**Harnett County**  
420 McKinney Pkwy  
LILLINGTON, NC 27546  
Phone:  
Fax:

**SUBJECT: ERES2304-0069**  
**ELECTRICAL RESIDENTIAL**

Here are the results of all Inspections located at **89 CALDWELL ST:**

DATE: 1/11/2023
SHEET NAME ELECTRICAL LINE & CALCS.
SHEET SIZE ANSI B 11" X 17"
SHEET NUMBER PV-7

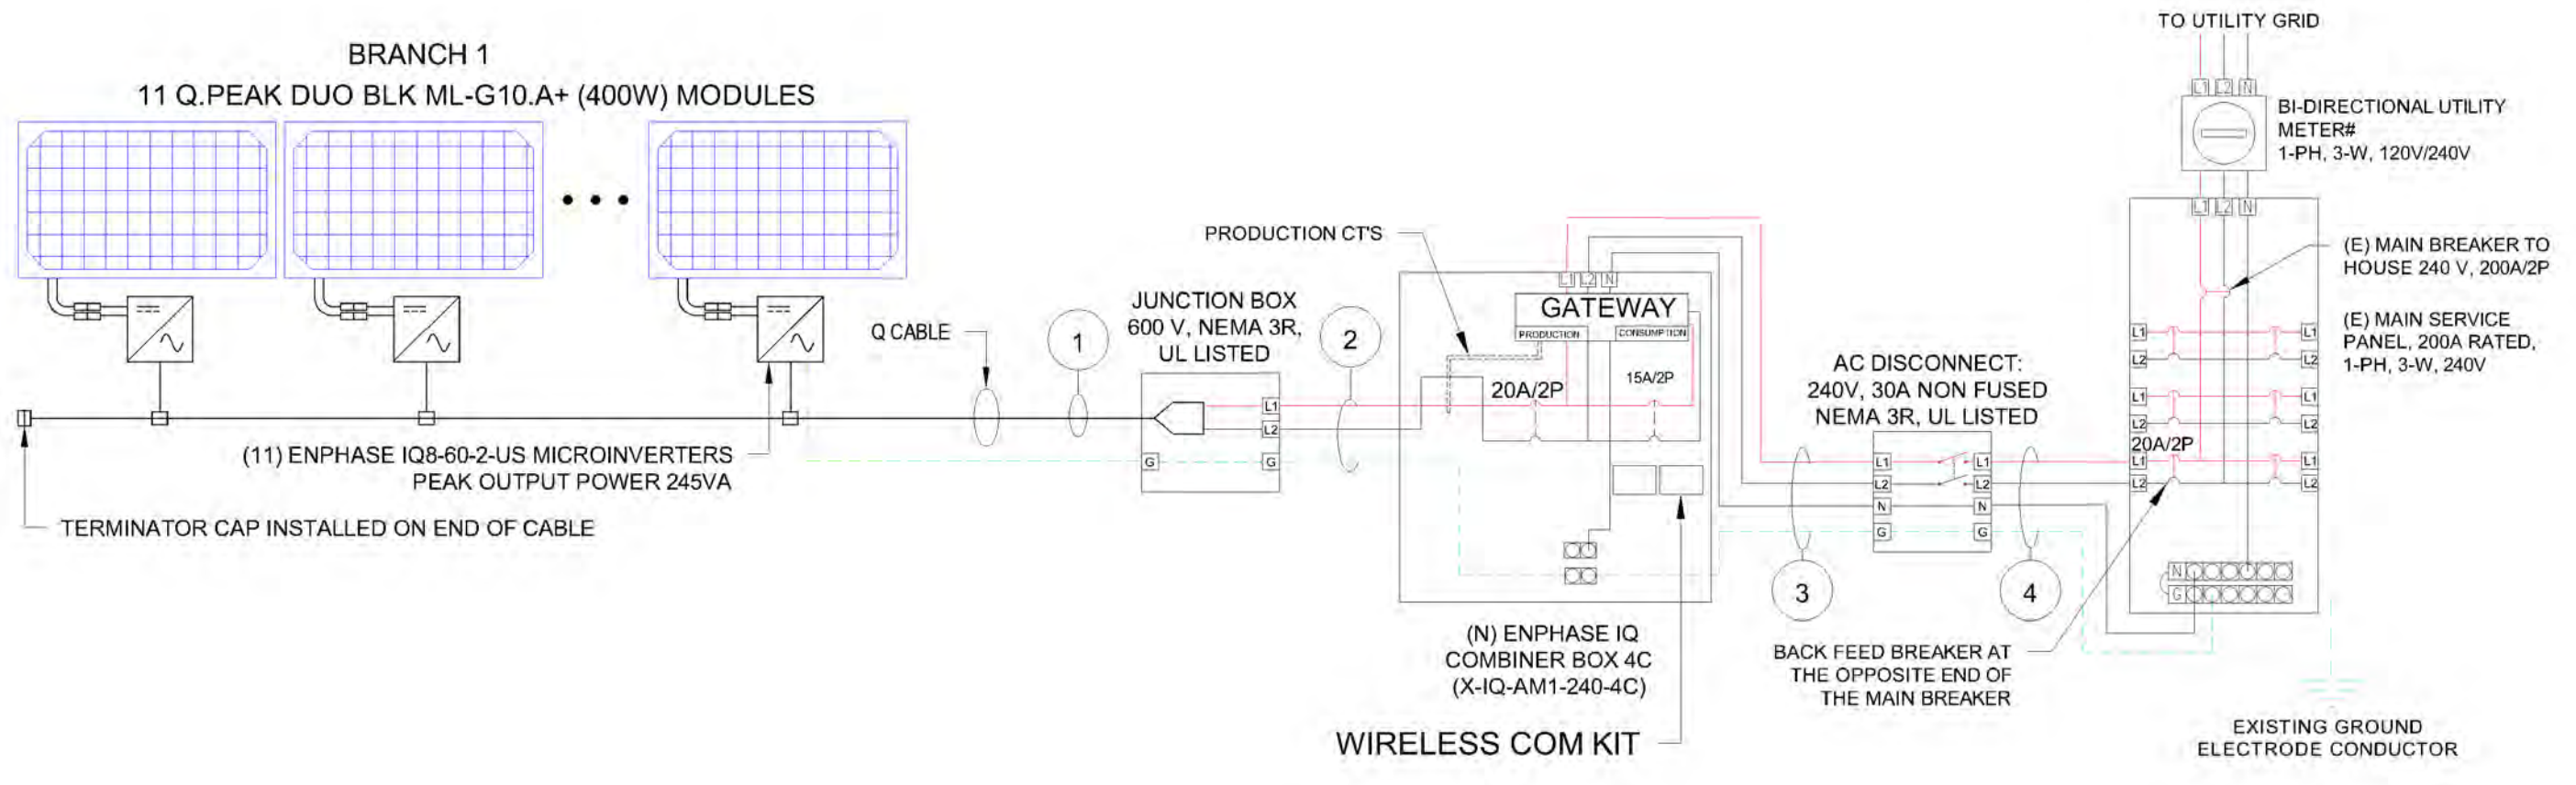
Inspection Type: FINAL\*\*  
Scheduled Date/Time: 5/16/2023  
Completed Date/Time: 5/16/2023  
Inspector: John B Kokoszka  
Result: DISAPPROVED  
Remarks:  
Notes: Need to up load all the pictures of the install only got a few. Max overcurrent device doesn't match the plans
